KITTITAS COUNTY

MEMORANDUM

TO: Dusty Pilkington, Community Development Services
FROM: Kelly Bacon, Engineer Technician I *KB*
DATE: November 30, 2017
SUBJECT: Jensvold BL-17-00017

The Public Works Department has reviewed the Request for Boundary Line Adjustment Application. In order to ensure that it meets current Kittitas County Road Standards, the applicant needs to provide the following prior to final approval:

SHEET 1 OF 2

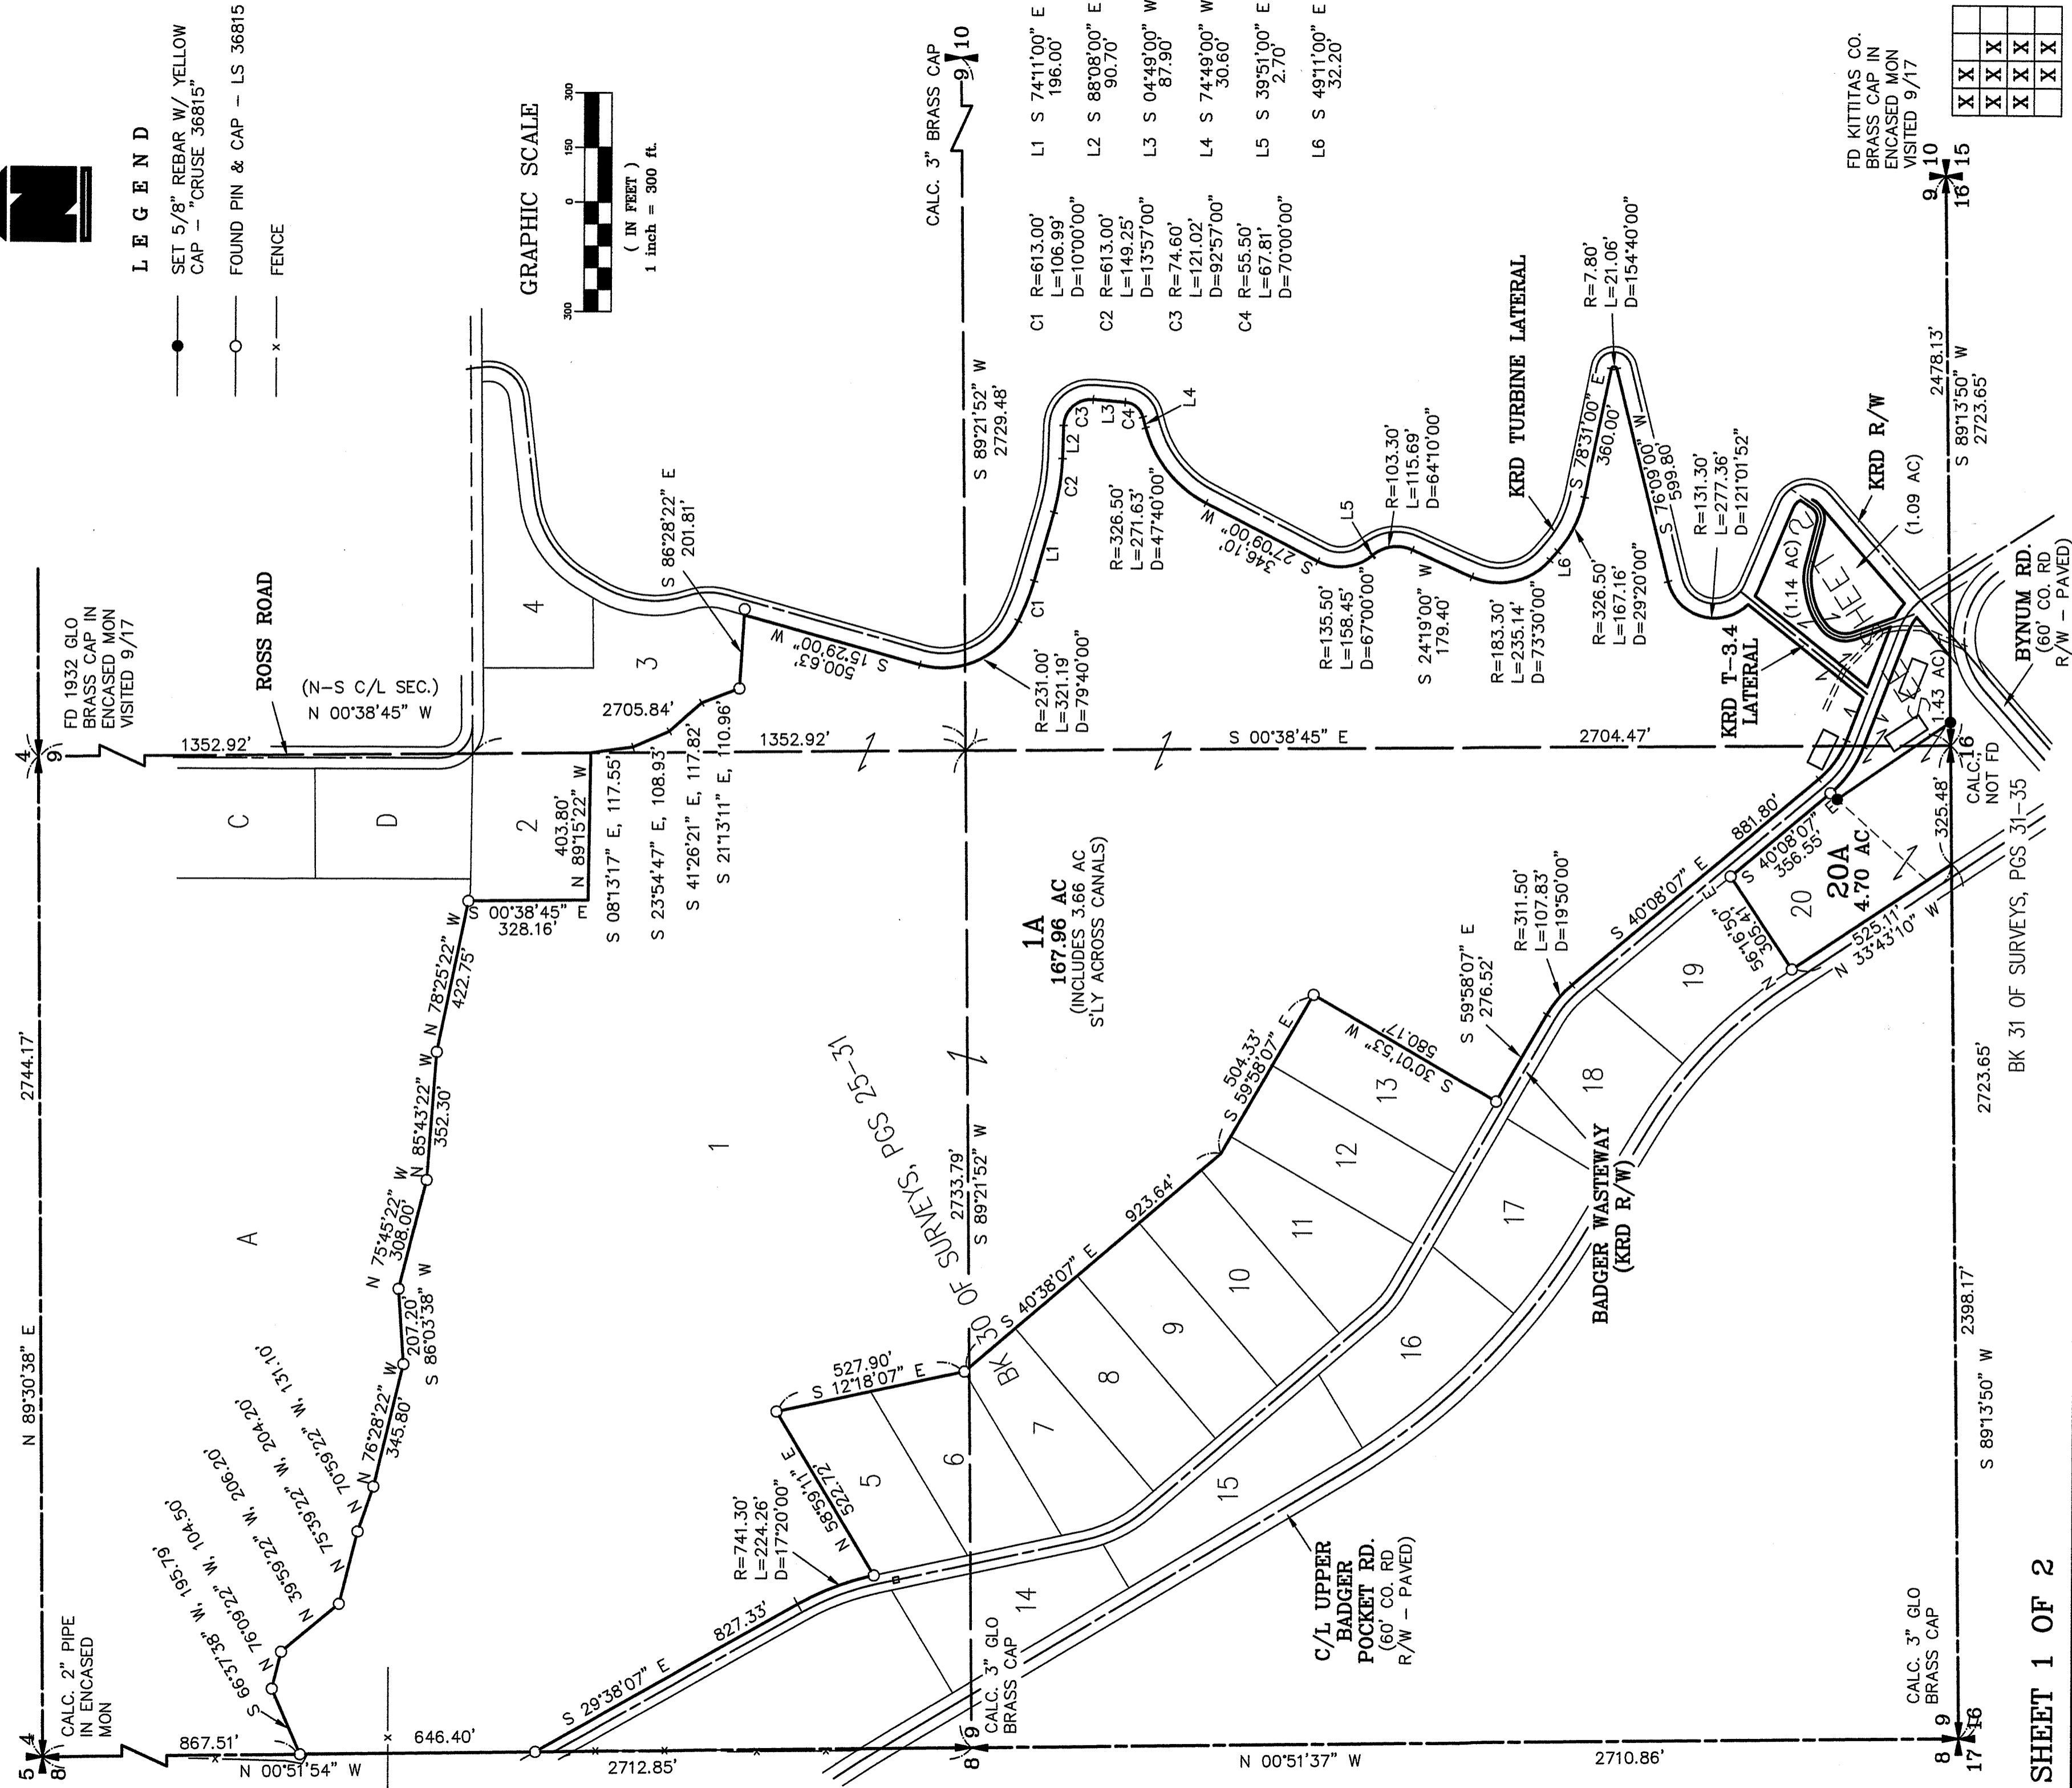
1. A revised legal description that describes the final configuration of the subject property shall be required.
2. Show access easements on the face of the BLA
